November 8, 2023

RE: CAO23-016
RFI #1
7235 East Mercer Way

The following issues have been addressed with our revisions.

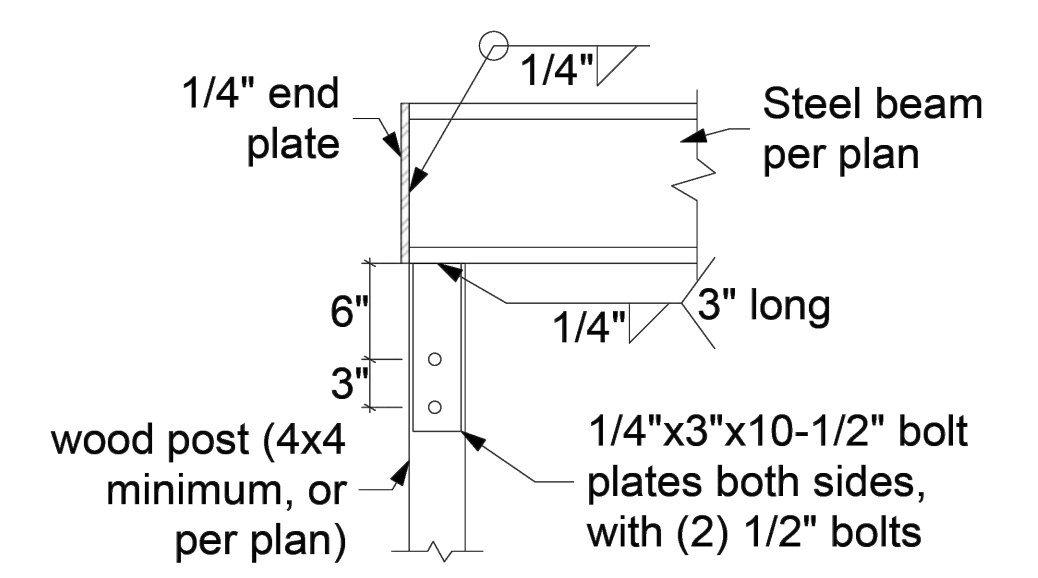
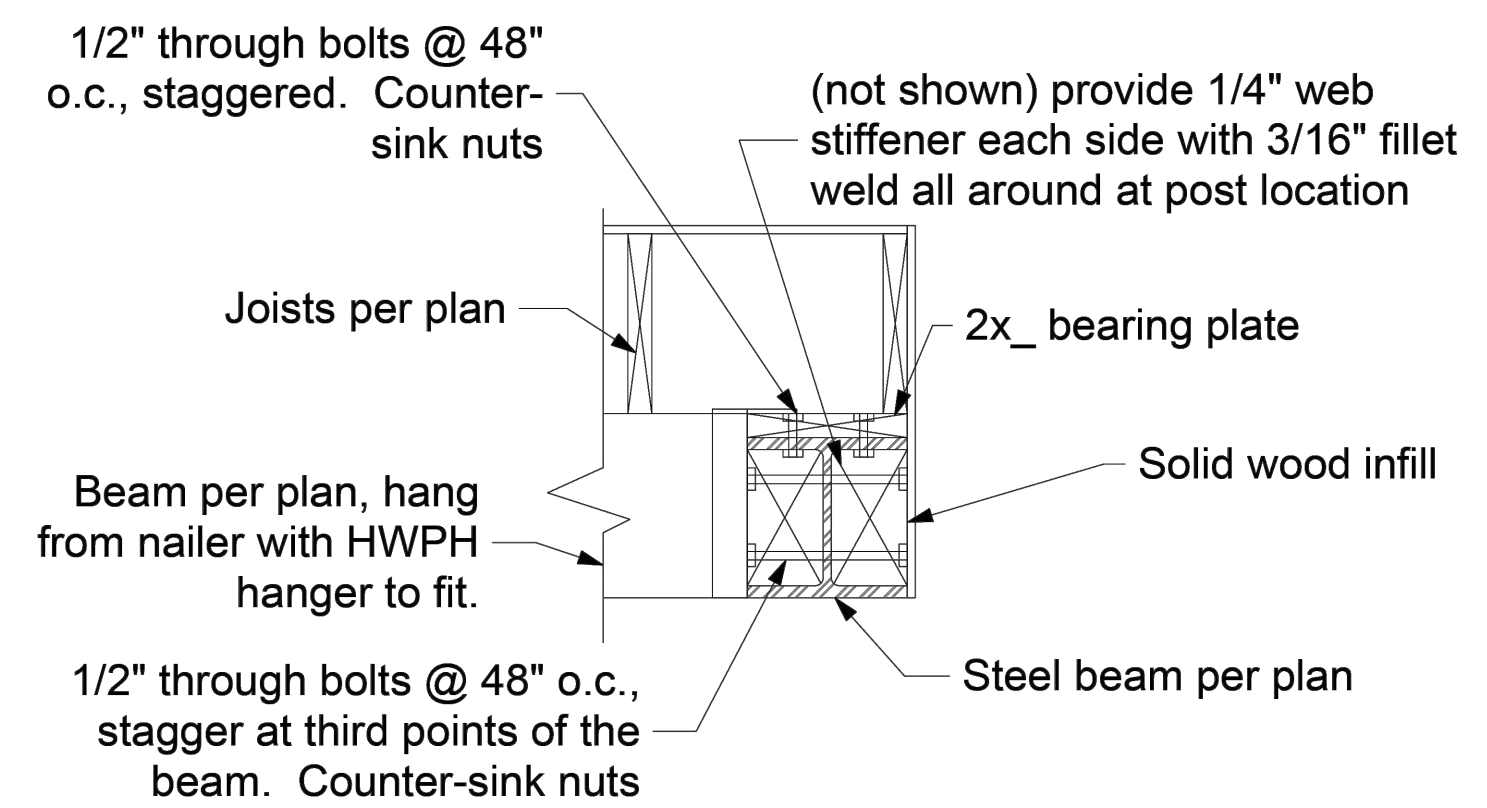
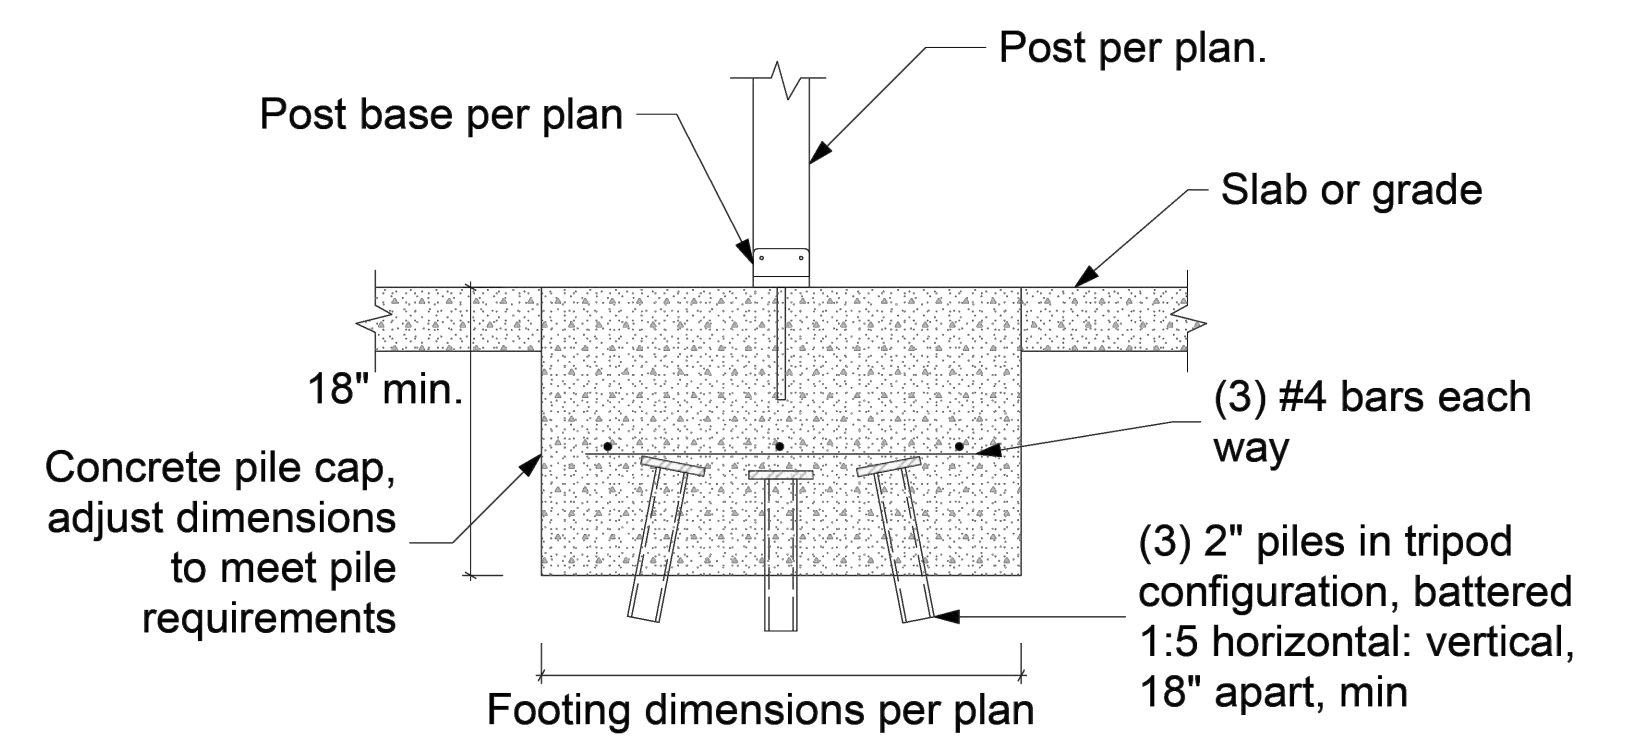
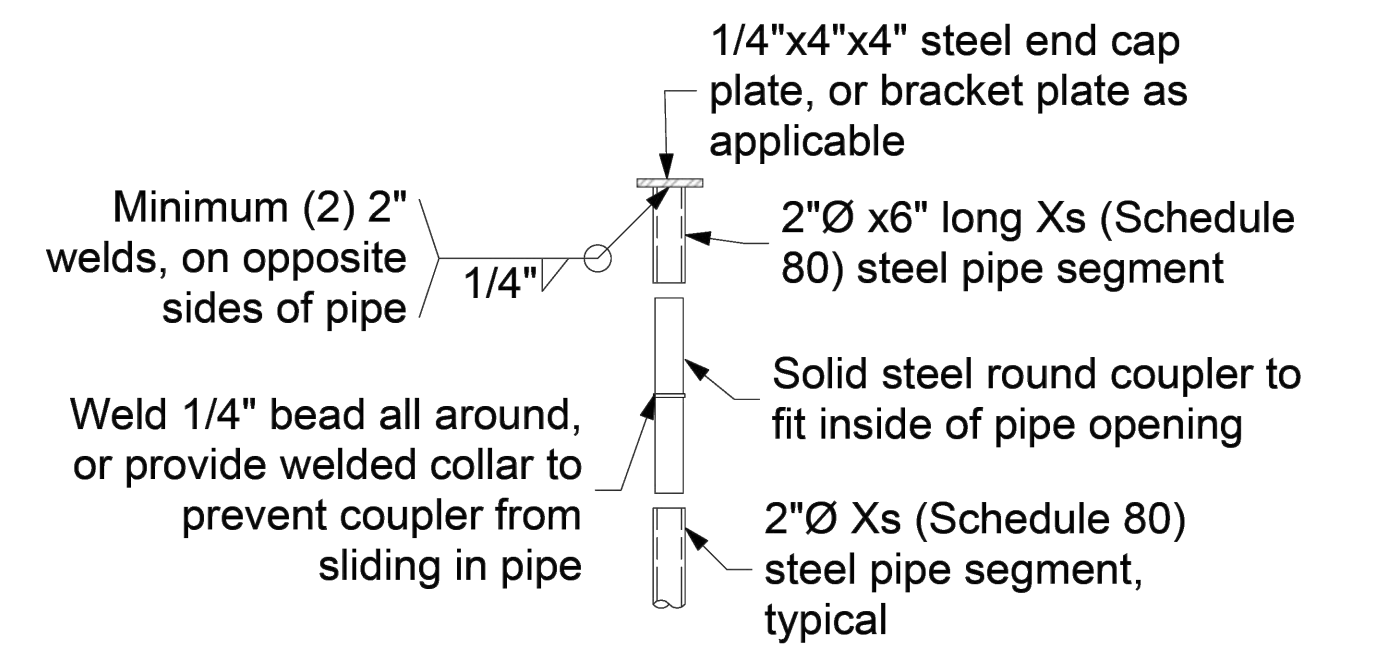
1. Please resolve the conflict between the geotechnical engineer's foundation recommendations in the geotechnical report and the foundations shown on the project drawings.

The revised plan set now reflects the geotechnical engineer's foundation recommendations. Please see sheet S-4.
